Recommendation Report for Planning Permission for Works or Extension to a Dwelling

**REF NO:** R/94/25/HH

**LOCATION:** Seascape  
5 West Mead  
Rustington  
BN16 2SL

**PROPOSAL:** Removal of existing flat roof garage and replacement with a pitched roof extension, new attached double garage and a detached car port. Alterations to existing fenestration. Roof alterations including amending the existing rear shed dormer to a flat roof dormer and the front facing shed dormer to a gabled dormer plus incorporation of rooflights.

Drawing Name: **Proposed Ground Floor Plan**

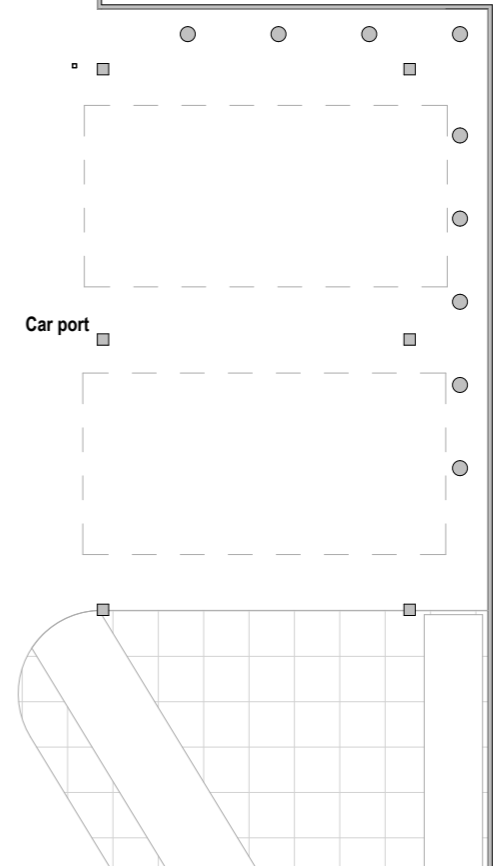
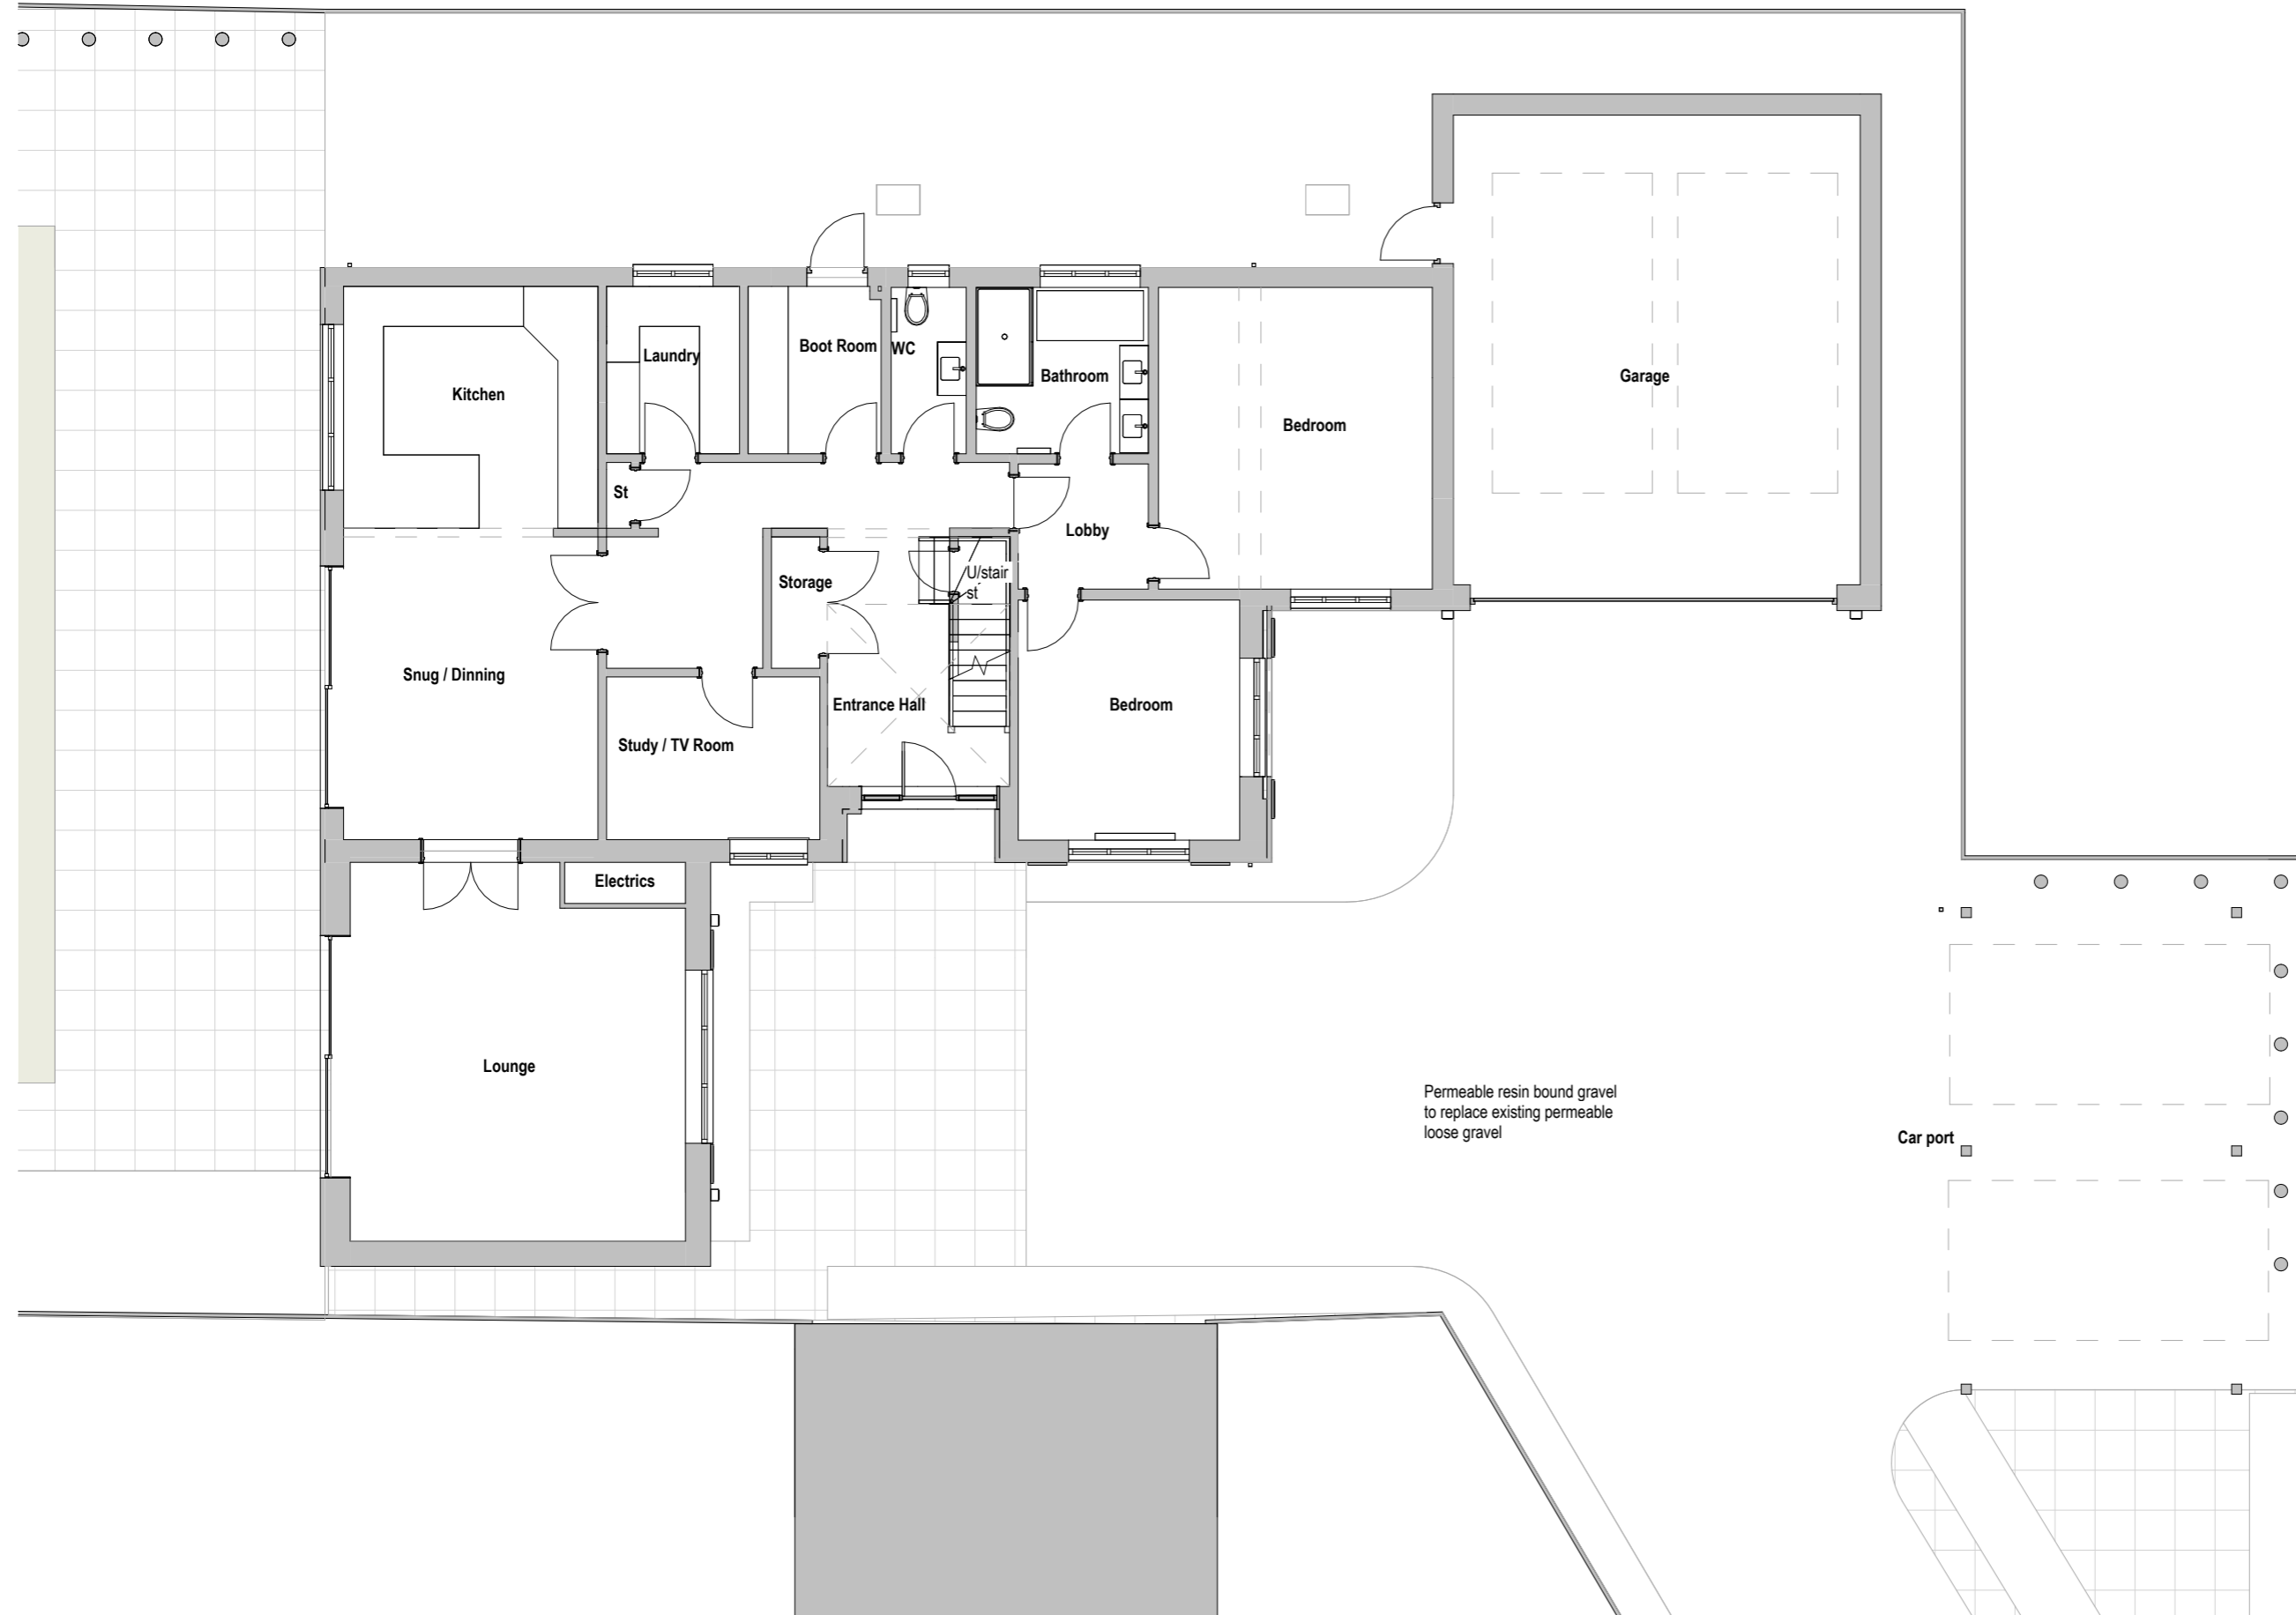
The proposed double garage extension to the north of the dwelling would have a width of 6.6m and a depth of 7.7m. The maximum height of garage would measure 5.1m and the height to eaves would measure approx. 2.1m. A door is proposed to the south (side) elevation of the garage. The garage would have a pitched roof with a roof light. The roof tiles are to match existing. The walls of the garage would feature white render to match the existing dwelling and a garage door to the front (east) elevation. The double garage is well integrated with the host dwelling and would be finished in materials that are similar to the host dwelling in accordance with policy D DM4 of the Arun Local Plan (ALP).

The proposed single storey garage extension to the northern elevation of the host dwelling would be set in from the northern and western boundaries by 1.2m, and the neighbouring properties to the north and west are located some distance from the shared boundary with the application site. As such, given the spacing maintained between the extension and neighbouring properties and the eaves height of the garage extension, the proposed garage extension would not result in overbearing or overshadowing impacts to neighbouring properties. A door is proposed within the southern elevation of the garage, with

garage doors and a high level window within the western elevation, facing the street scene. The proposed garage would not result in any overlooking.

Proposed Roof Plan

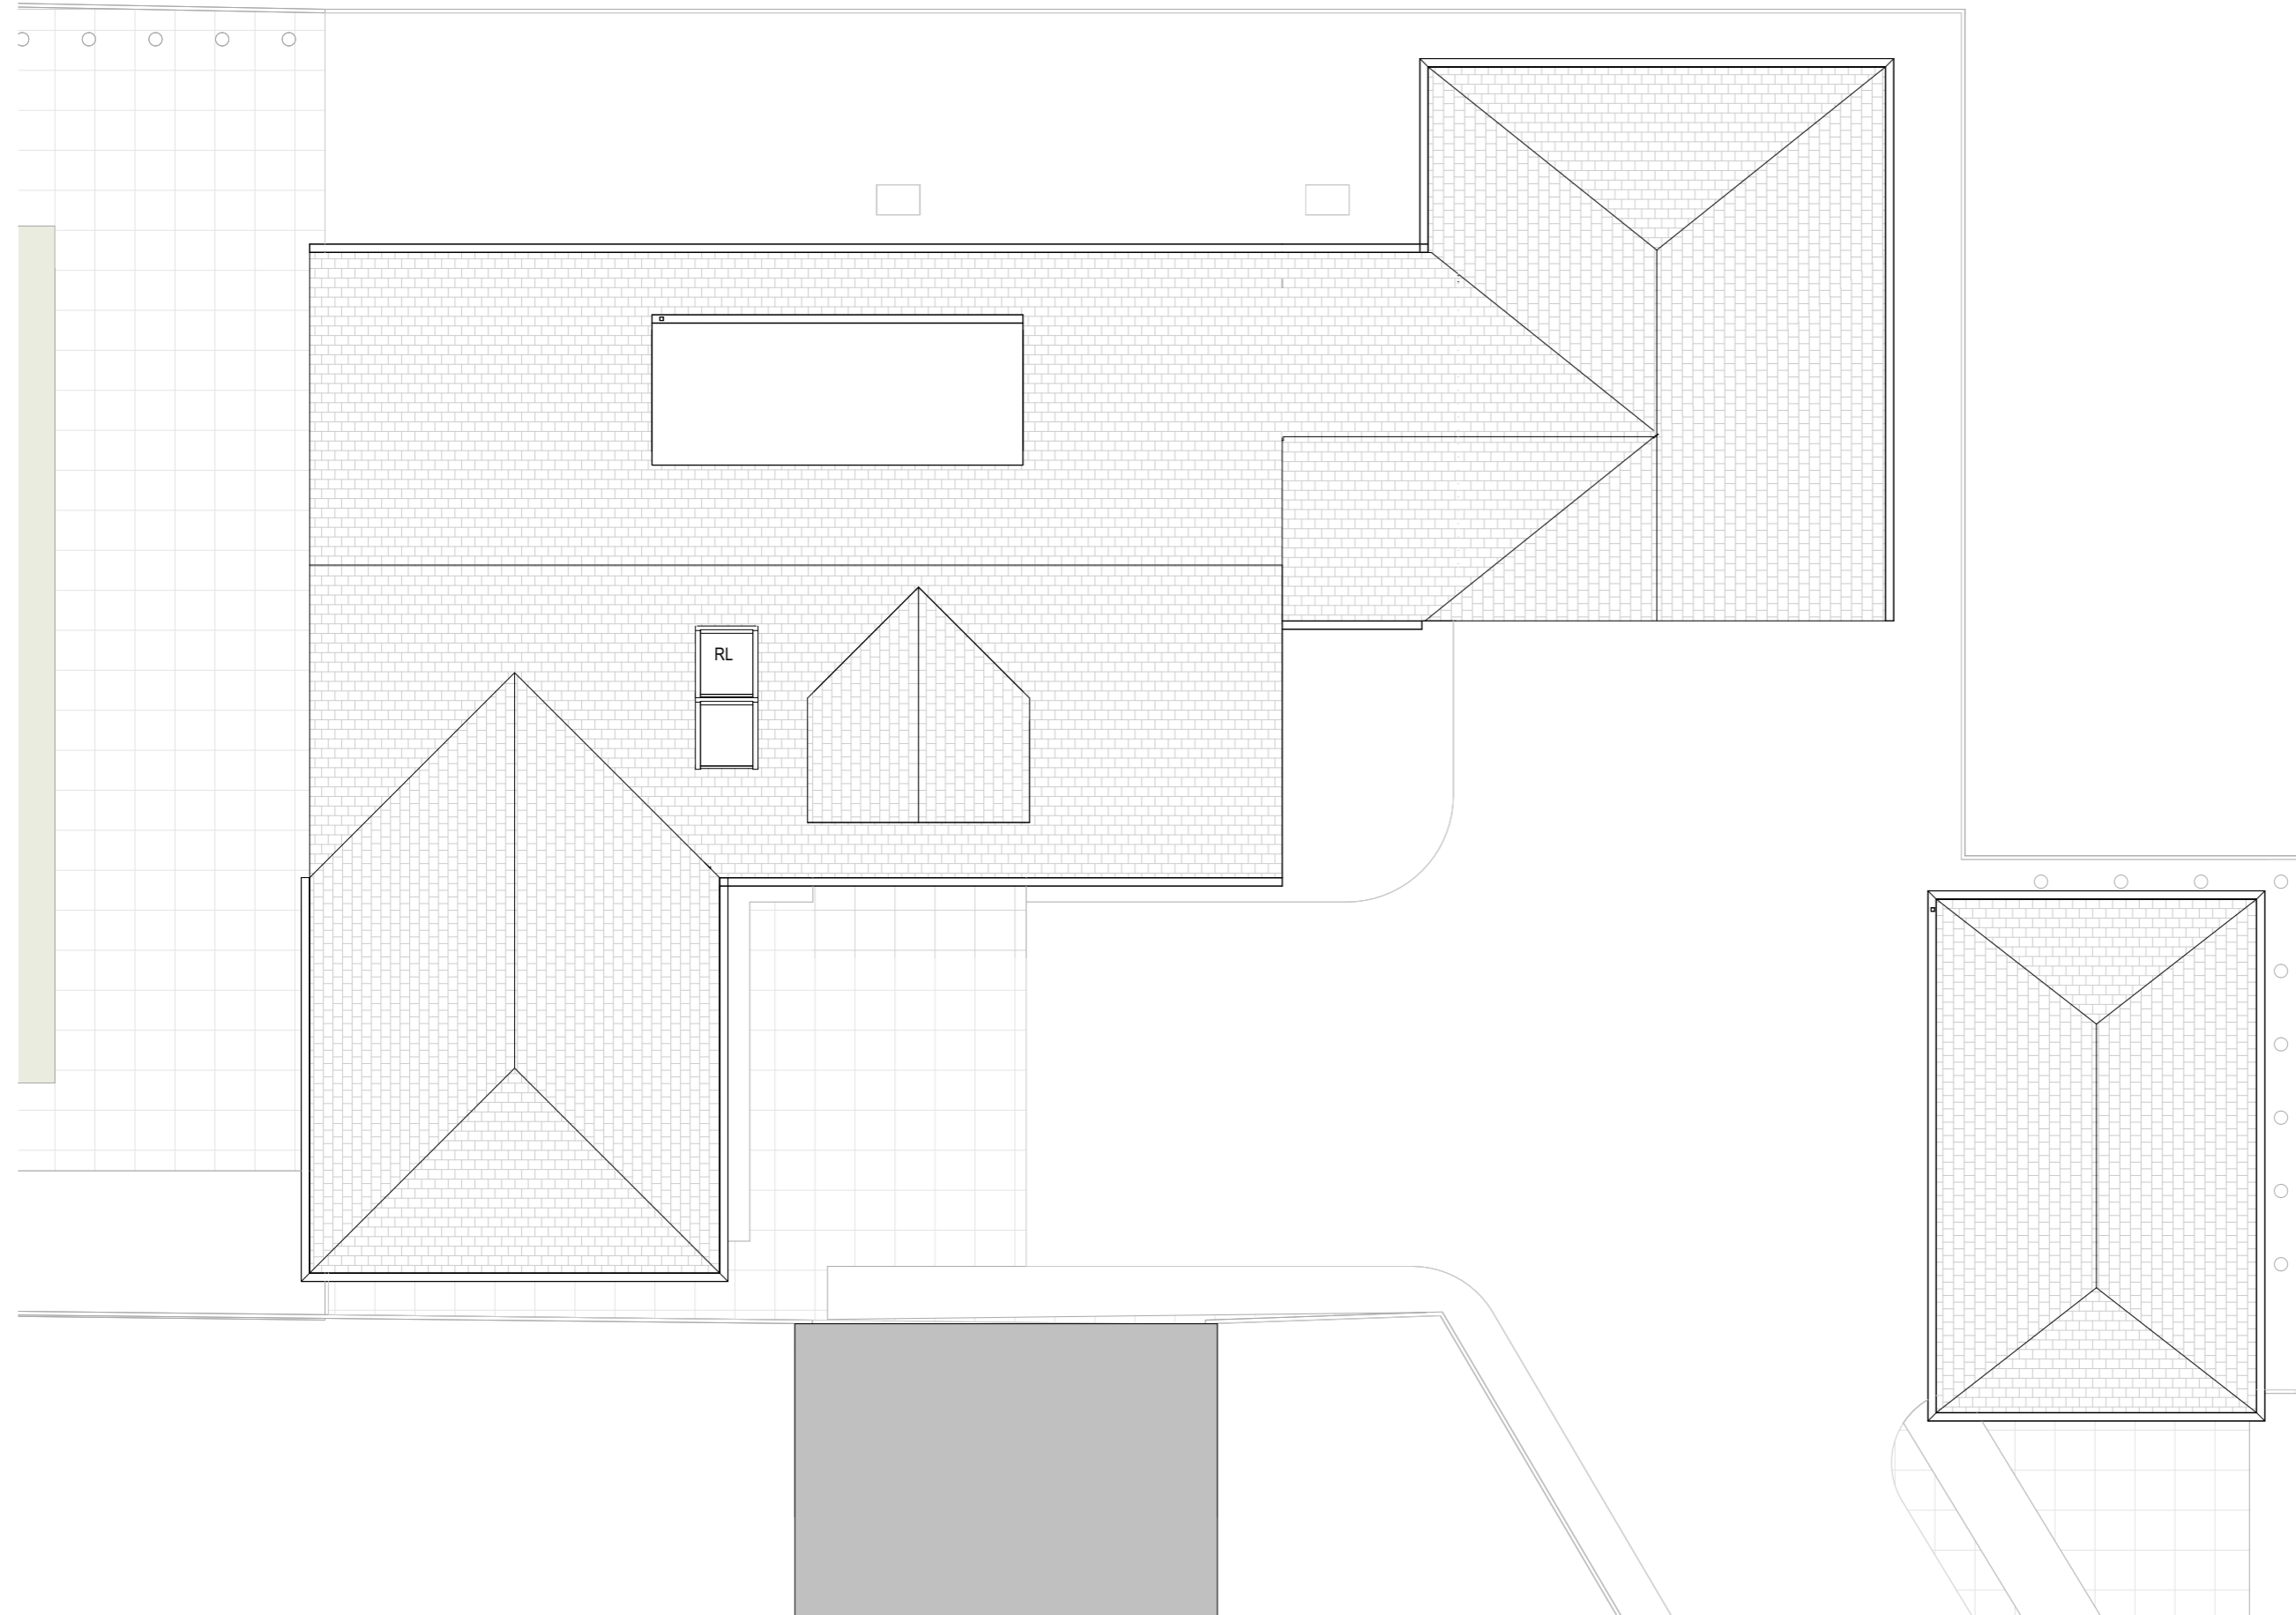
The existing dormer within the eastern roof slope is to be converted to a pitched roof dormer of a lesser width. The front dormer would be proportionately positioned within the front roof plane and will measure approx. 3.3m wide x 3.5m deep x 3.2m high. The pitched roofed dormer would appear well integrated with the roofscape of the dwelling. The walls of the dormer will feature cream cladding, and the roof will feature grey slate tiles matching that of the existing dwelling.

Two rooflights are proposed to the eastern roof slope of the dwelling. The rooflights would be proportionate in scale and number and would not result in any harm in this regard.

The proposed dormer within the western roof slope would be larger in width than the existing dormer which it would replace, and the roof will be altered to feature a flat roof. The dormer will now measure approx. 2.1m in depth, 5.5m in width and 1.9m in height. Windows serving the bathroom are proposed within the dormer. The walls of the dormer would be finished in grey slate tiles to match the existing roof of the dwelling, and the dormer will feature a flat roof. The proposed development would alter the original character of the property, however the main roof ridge height would be retained, and the development would not project beyond the original footprint of the property which helps to minimise any visual harm upon the locality, which complies with the Arun Design Guide (ADG). Overall, the proposed works would alter the character of the property, however, it is noted that the proposed dormer would replace a dormer of a similar design and scale and the area is varied in terms of roof alterations and extensions. Therefore, the proposal would not appear out of character.

Proposed South and West Elevations

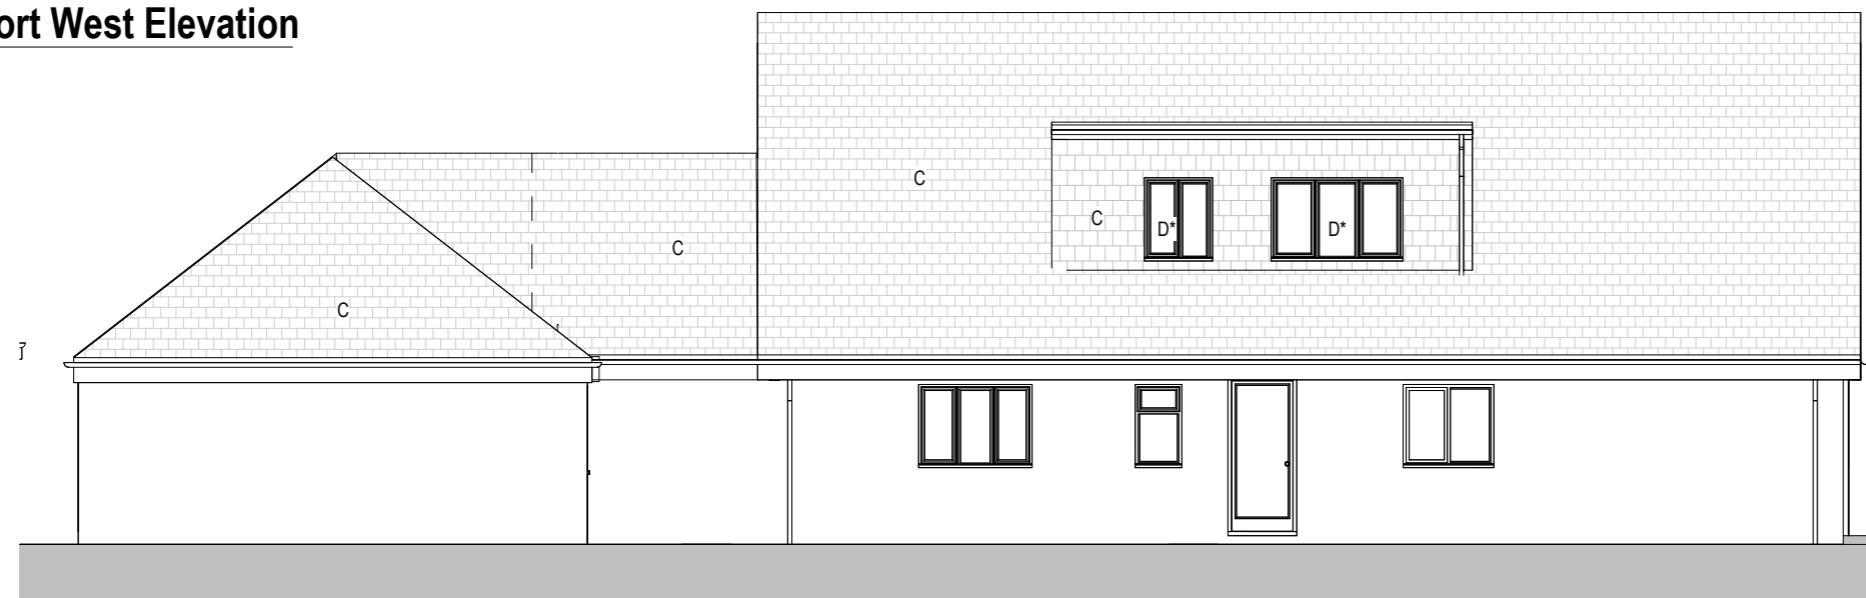
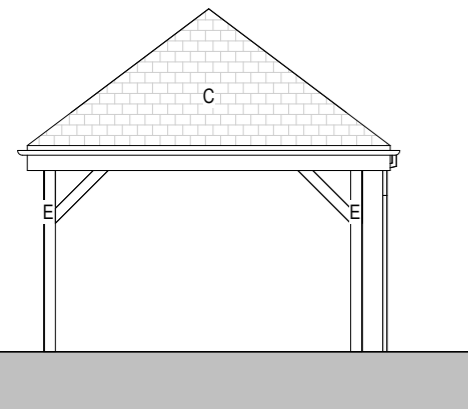
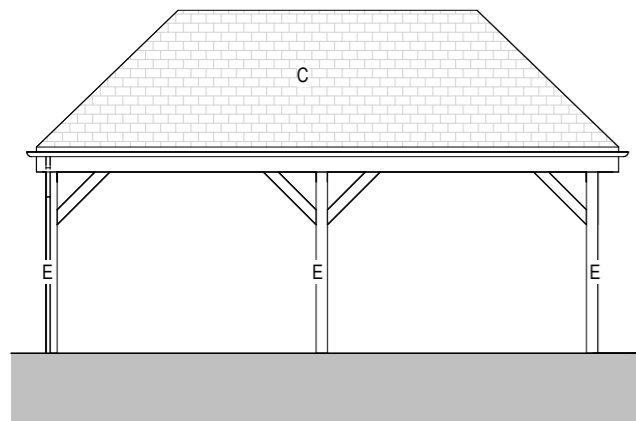
The proposed dormer within the western roof slope would be contained within the existing western roof slope and would not result in overshadowing or overbearing impacts to neighbouring properties as it is set in 3.2m from the western boundary. As such, the proposed dormer would not result in harm to neighbouring properties by way of overbearing or overshadowing impacts. The windows proposed within the western dormer are indicated to be obscurely glazed on the submitted plans. The proposed windows would serve a bathroom, and given that additional windows are proposed when compared to the existing situation, a condition will be attached to this planning permission to require the bathroom windows shall be obscurely glazed and non-openable below 1.7m above the internal finished floor level, to prevent unacceptable overlooking from occurring.

The proposal would include additional glazing within the rear, southern facing gable end, at first floor level. Given that there is existing first floor level fenestration within the gable facing to the south, the proposed fenestration would not offer significantly different views to those already available from the existing fenestration. As such, the proposed additional first floor level glazing within the southern elevation would not result in unacceptable overlooking. The other alterations to fenestration are at ground floor level. Given that there is fenestration currently along all elevations, the proposed fenestration will not result in any additional overlooking or overbearing impact and are acceptable.

- 3 The windows within the proposed dormer to the western roof slope shall at all times be glazed with obscured glass to a level equivalent to Pilkington Level 3 or nearest equivalent standard and be non-openable below 1.7m above finished floor level. This arrangement shall be permanently retained thereafter.
